Application No: AW/262/25/PL
Site Address: Public Conveniences Marine Park Gardens Marine Drive West Aldwick PO21 2QN
Description of works: Change of use from public conveniences (Sui Generis) to commercial use (use class E). This application is in CIL Zone 4 (Zero Rated) as other development.

Thank you for your internet representation made on 24th November 2025 which has been recorded as no objection with the comments as follows:

DRAWING TITLE
 PROPOSED FLOOR PLAN & ELEVATIONS

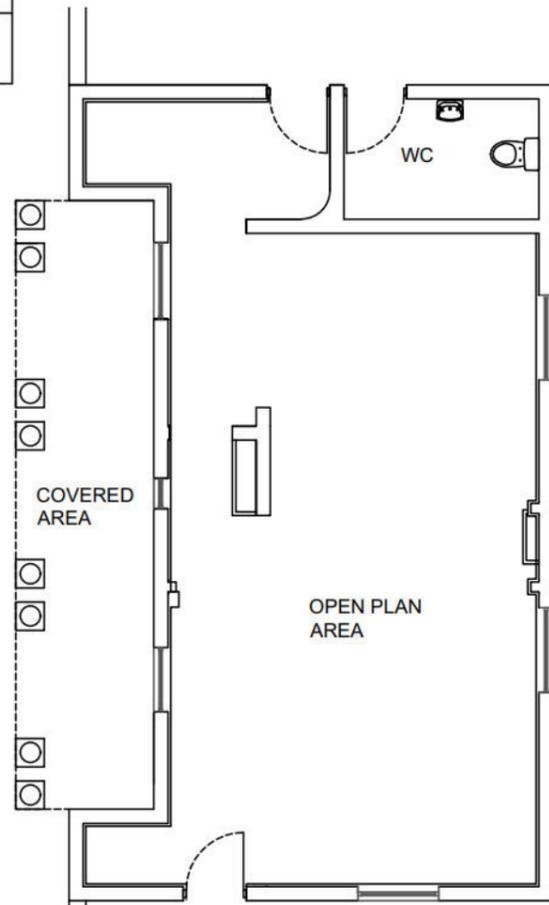
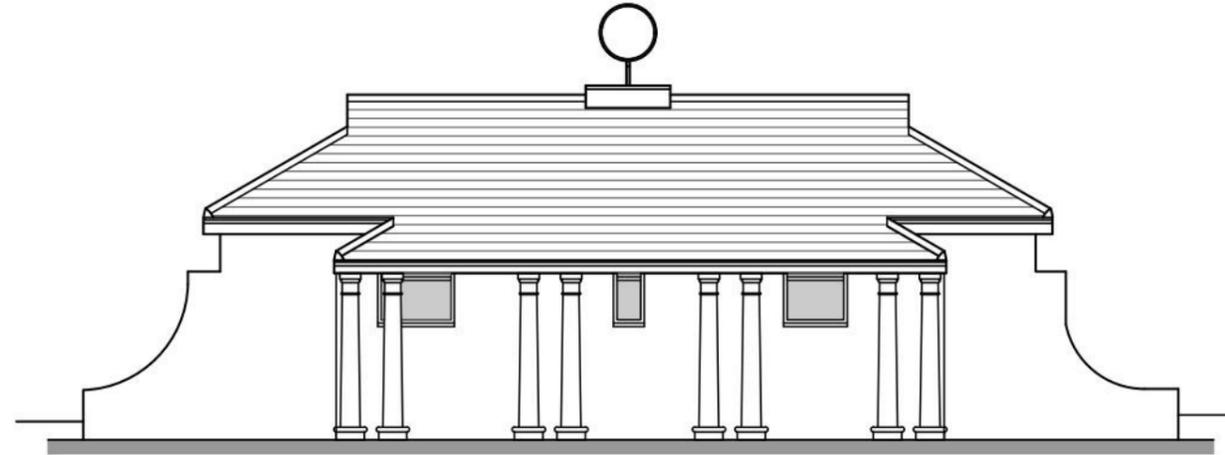
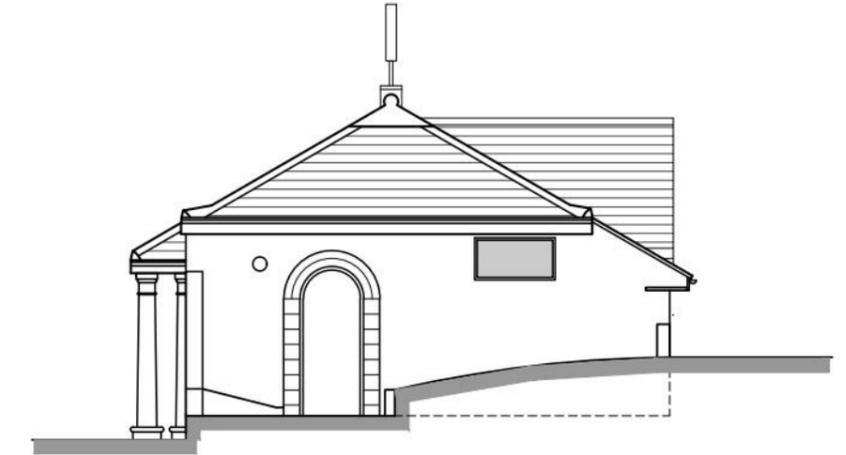
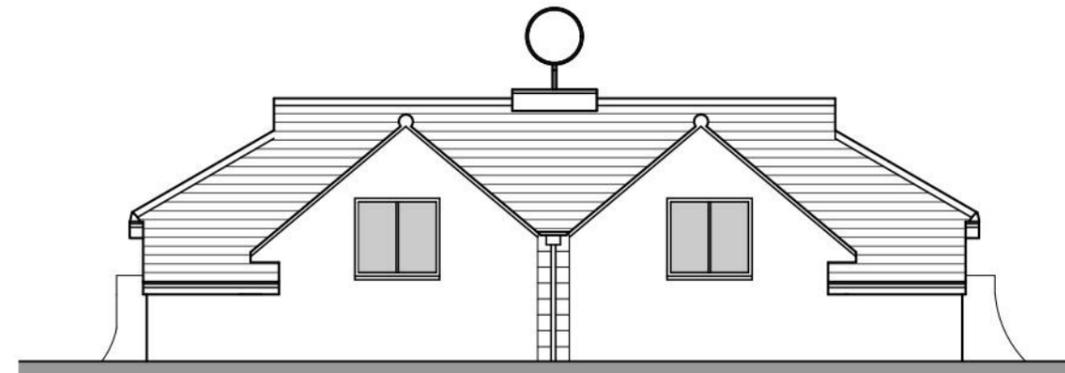
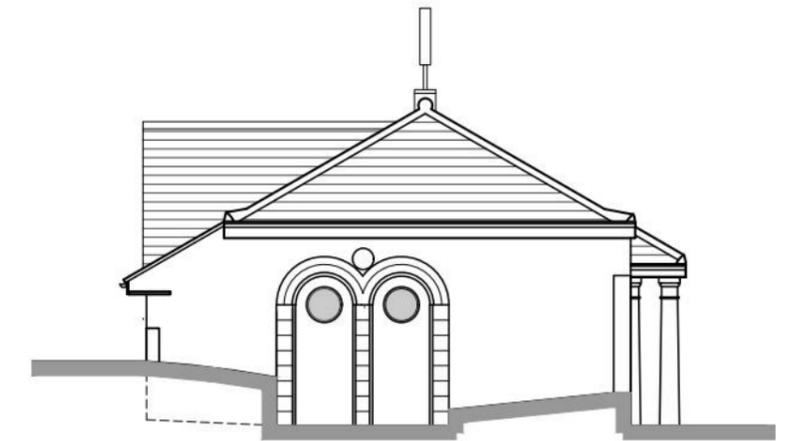
The current plan provides for one toilet, which appears to have its own entrance at the rear of the property. On the basis that it should be publicly accessible to all, I would argue that there is a case for two WCs. It is crucial that this facility is available to members of the general public and is not restricted to the customers of the business. It is also important that free access is available so that the toilet door is not locked.
